ENFIELD INTERMODAL (MP05_0147) - PRECINCT E ARCHITECTURE PLAN SIGN OFF - CONDITION 1.8

I refer to the below Precinct E plan which the Department approved pursuant to Condition 1.8 of the Enfield Intermodal consent on 6 March 2020.

Figure 2 - Updated Precinct E plan for DPIE review / approval

1 E1 SITE & FLOOR PLAN

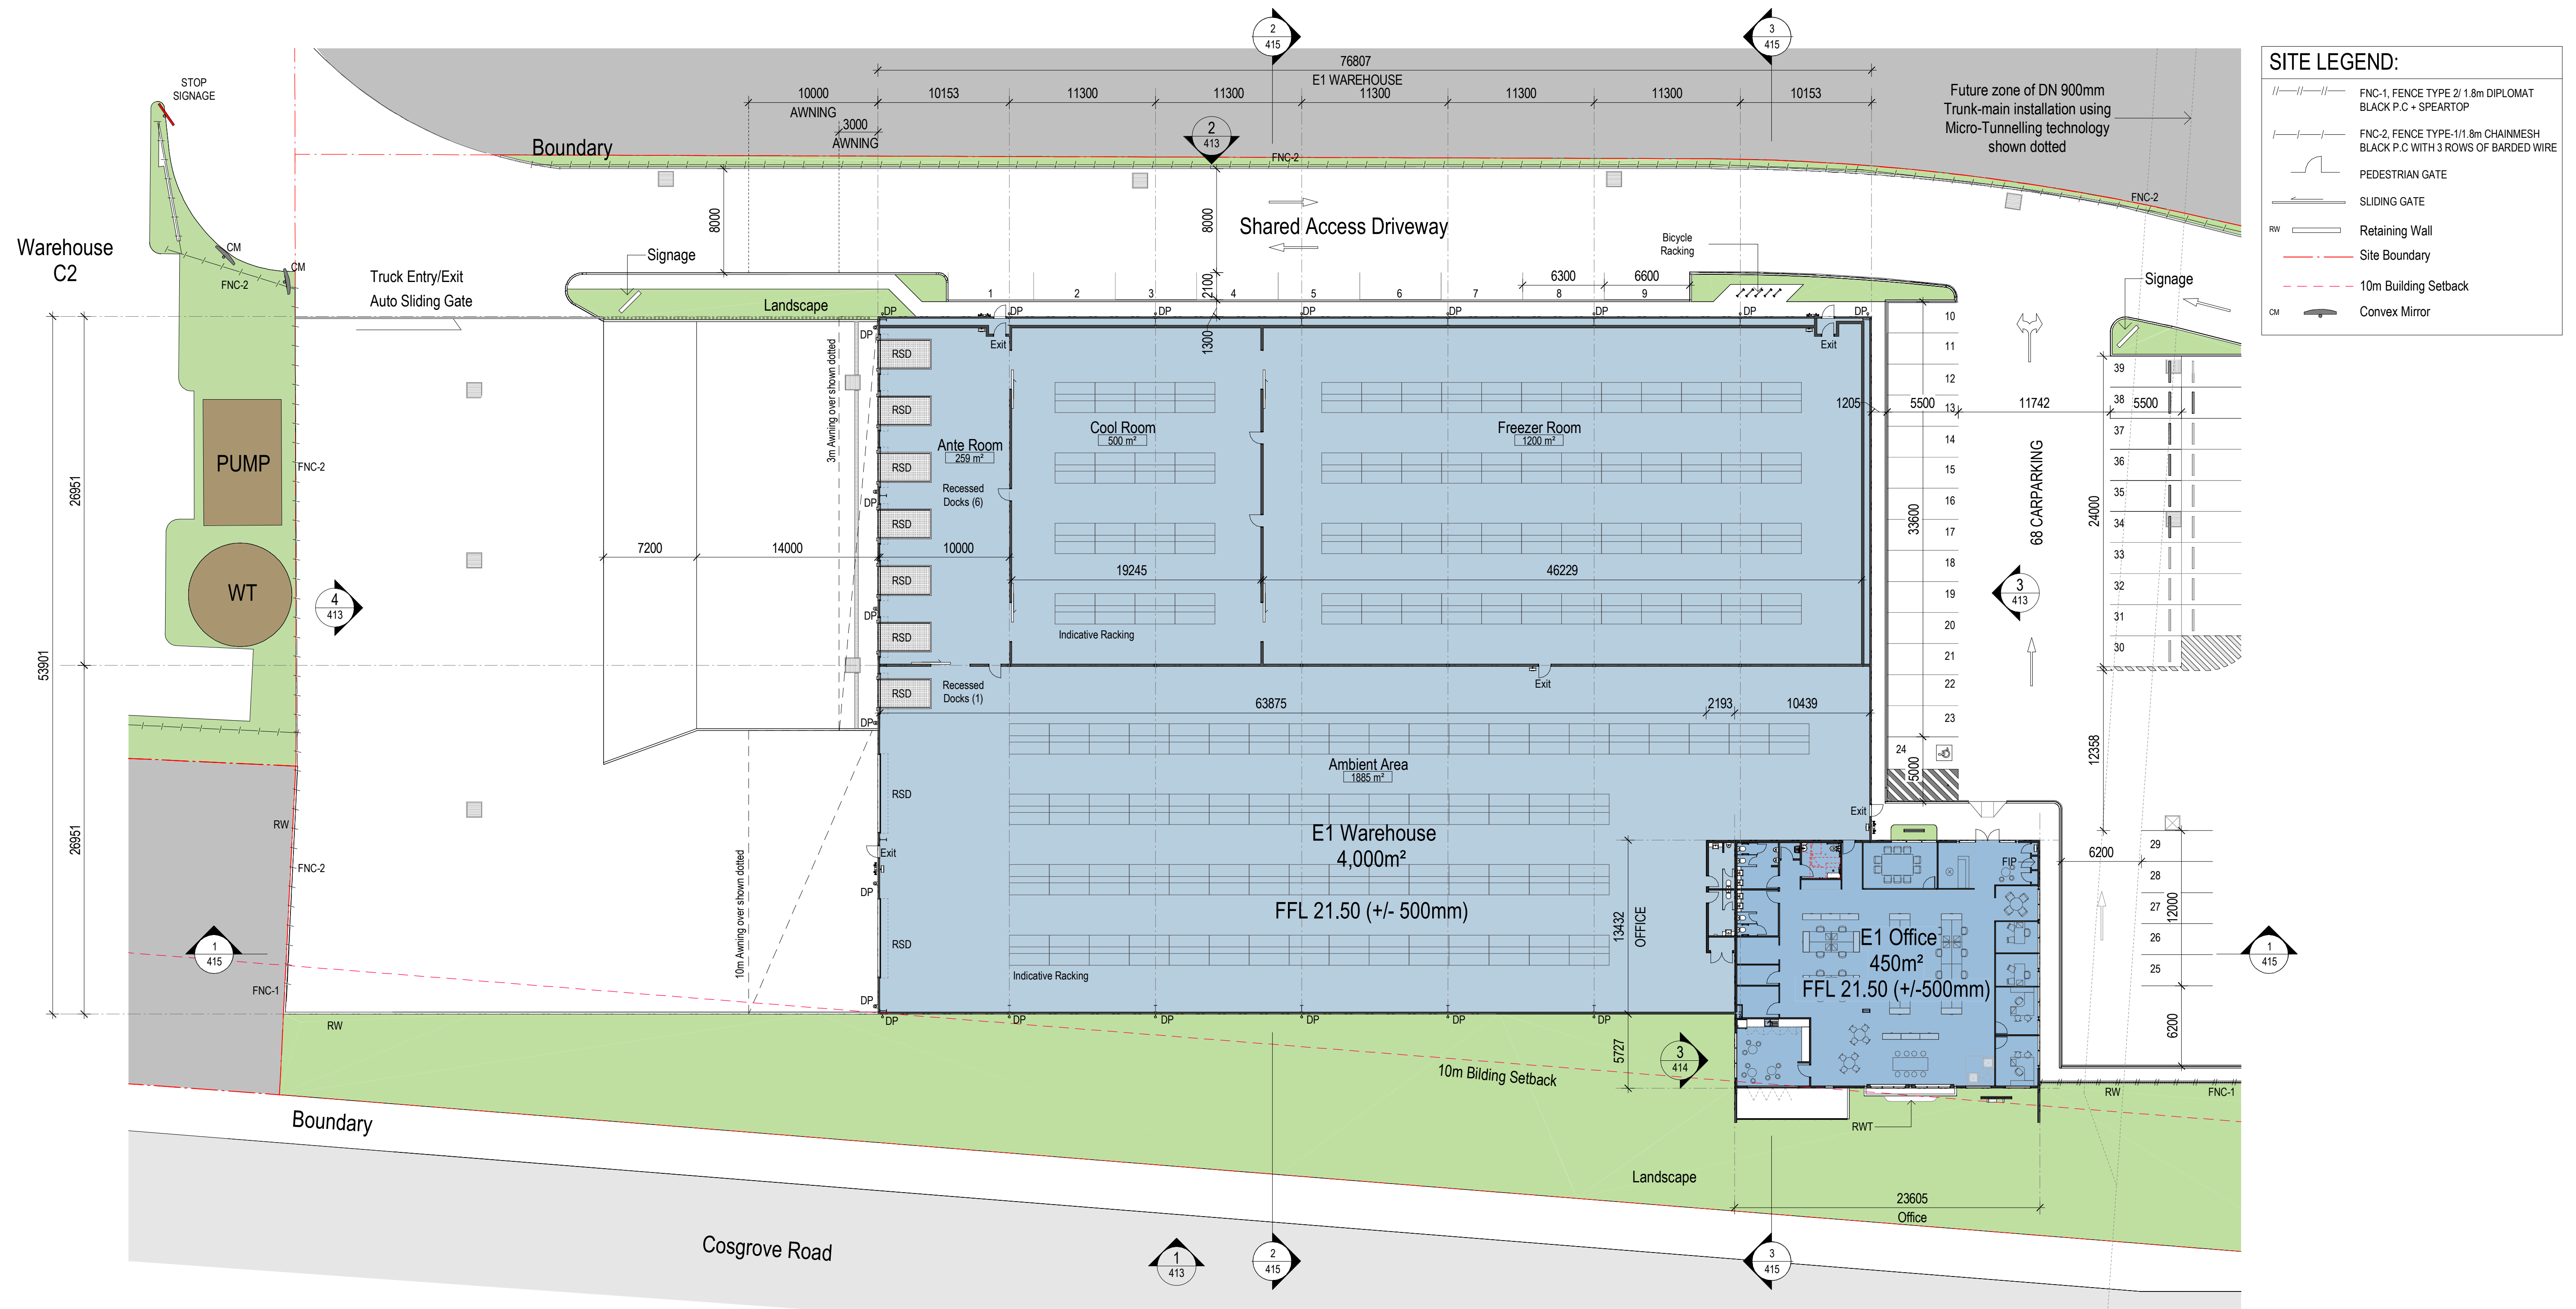
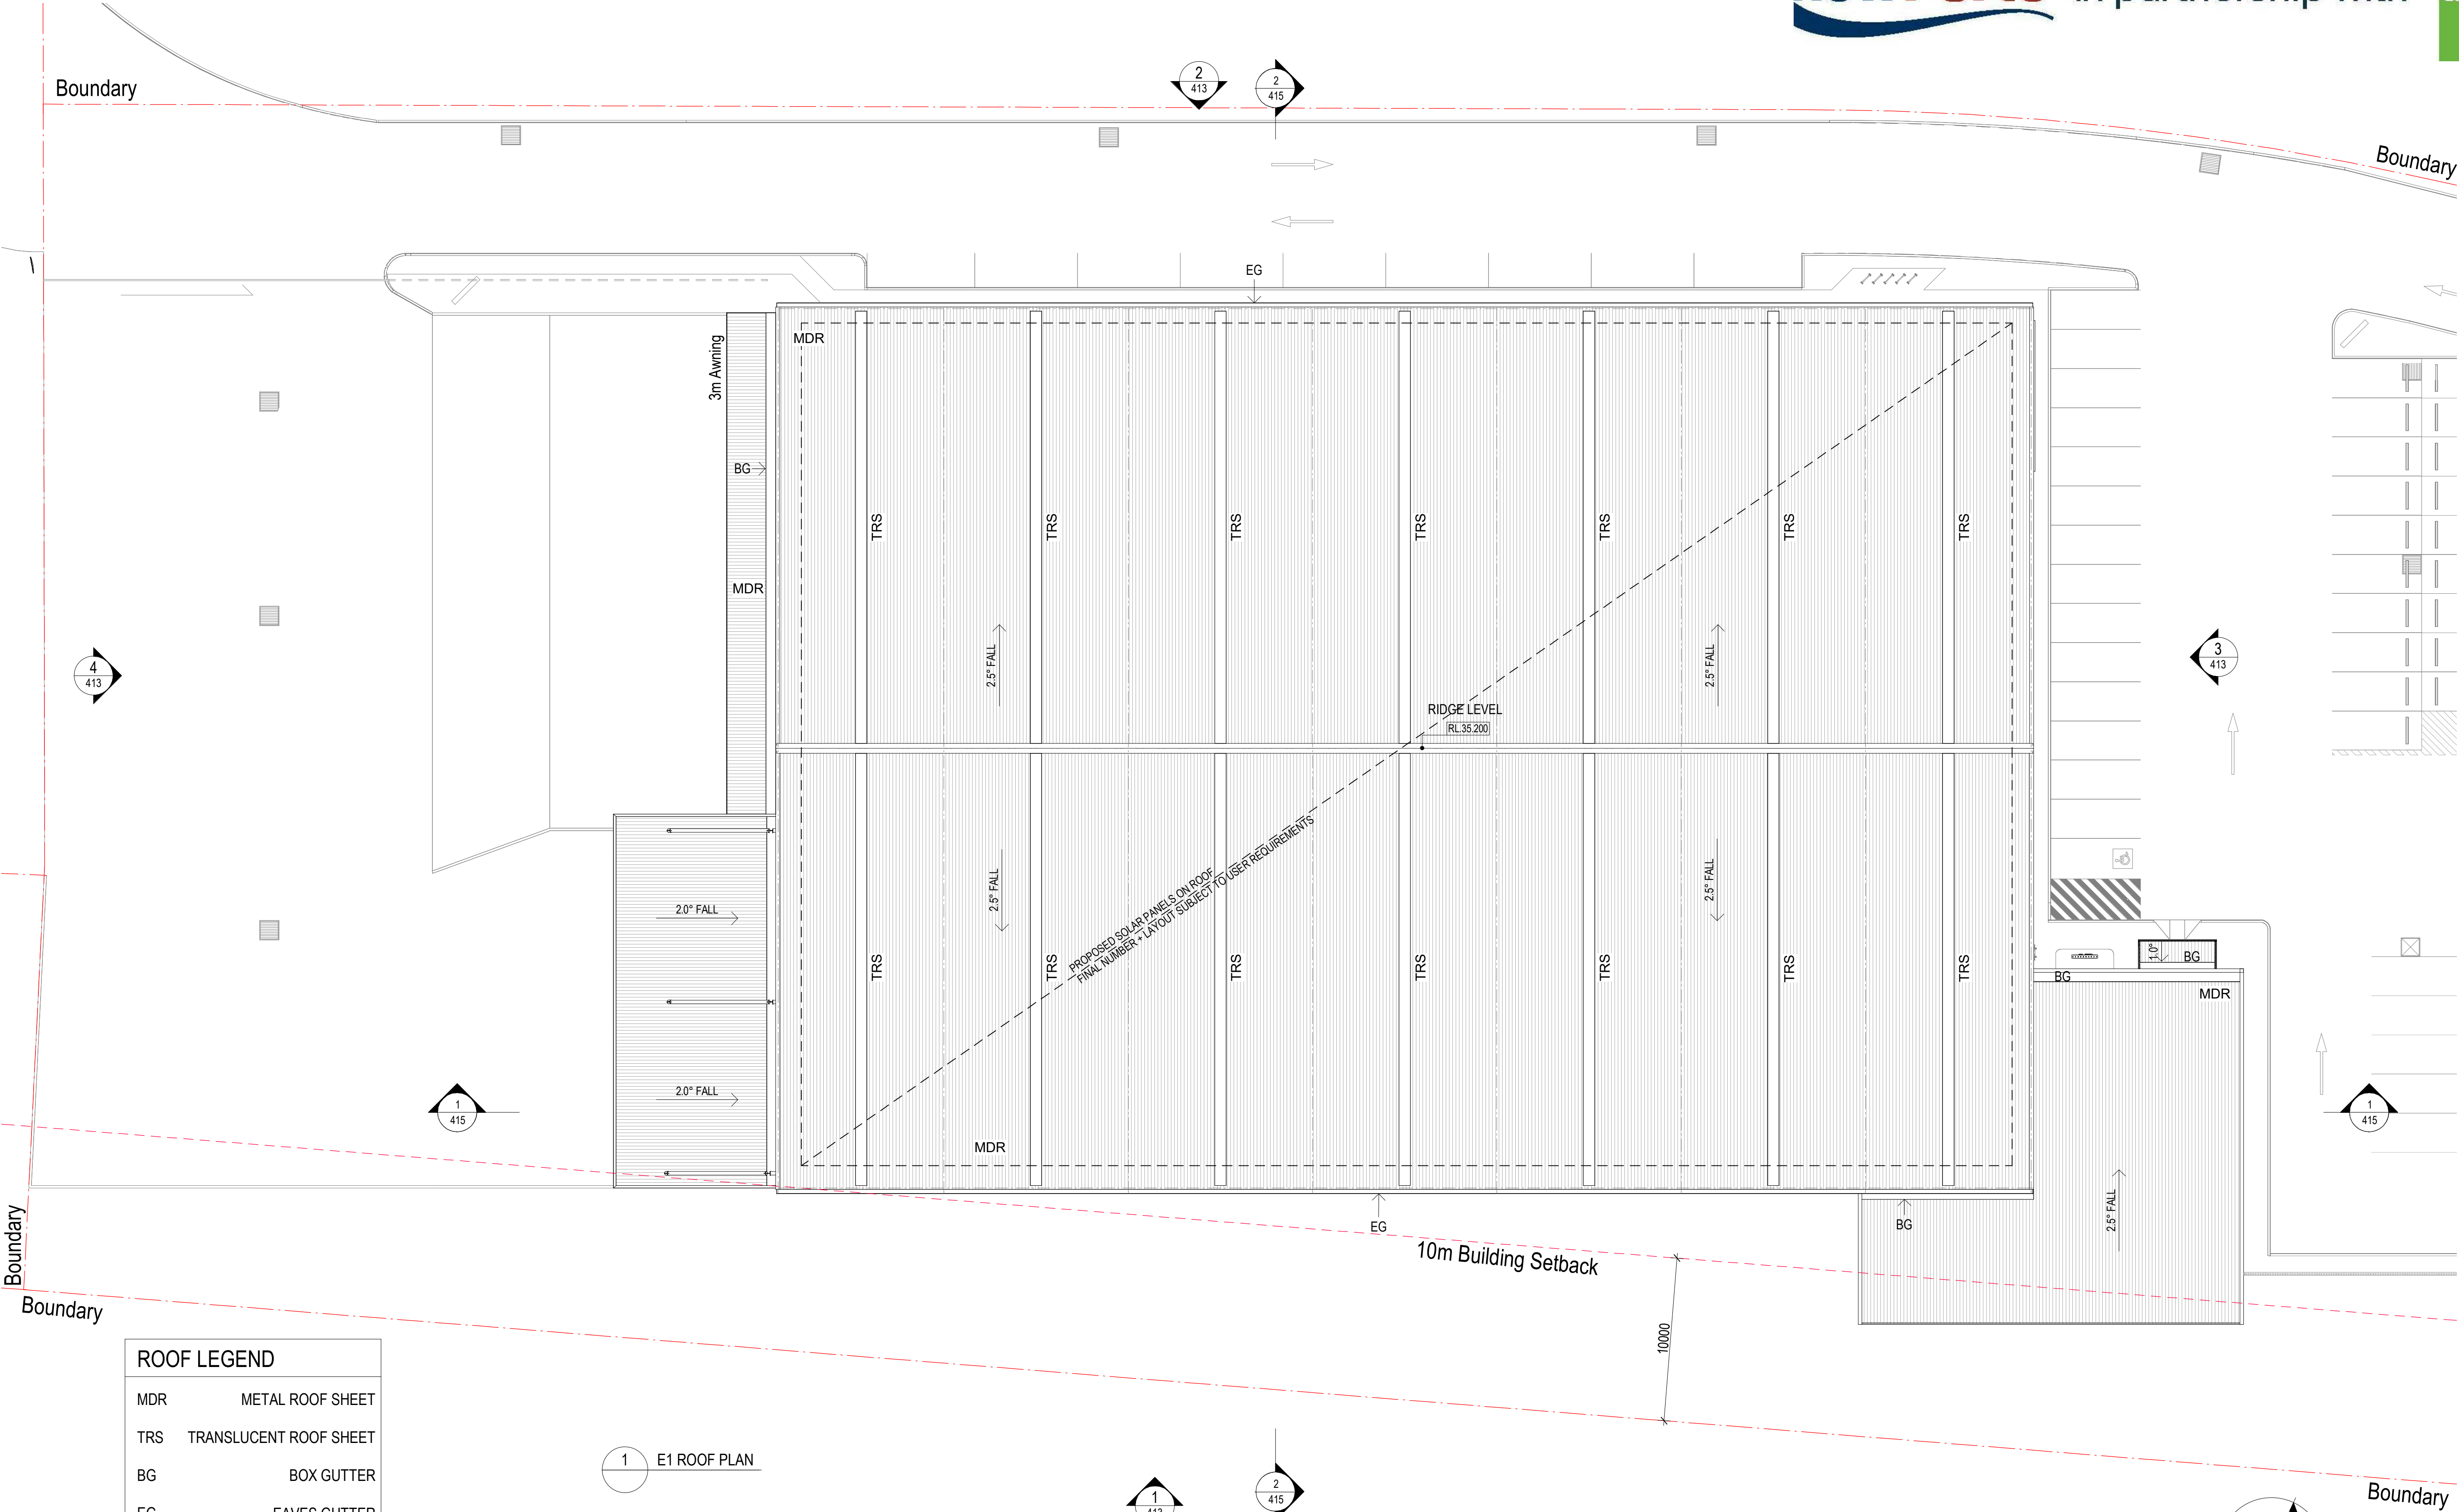
Warehouse E1

- 1) Reduction of recessed docks for from seven (7) to three (3)
- 2) New dock office (442sqm)
- 3) Awning increased from 10m to 15m
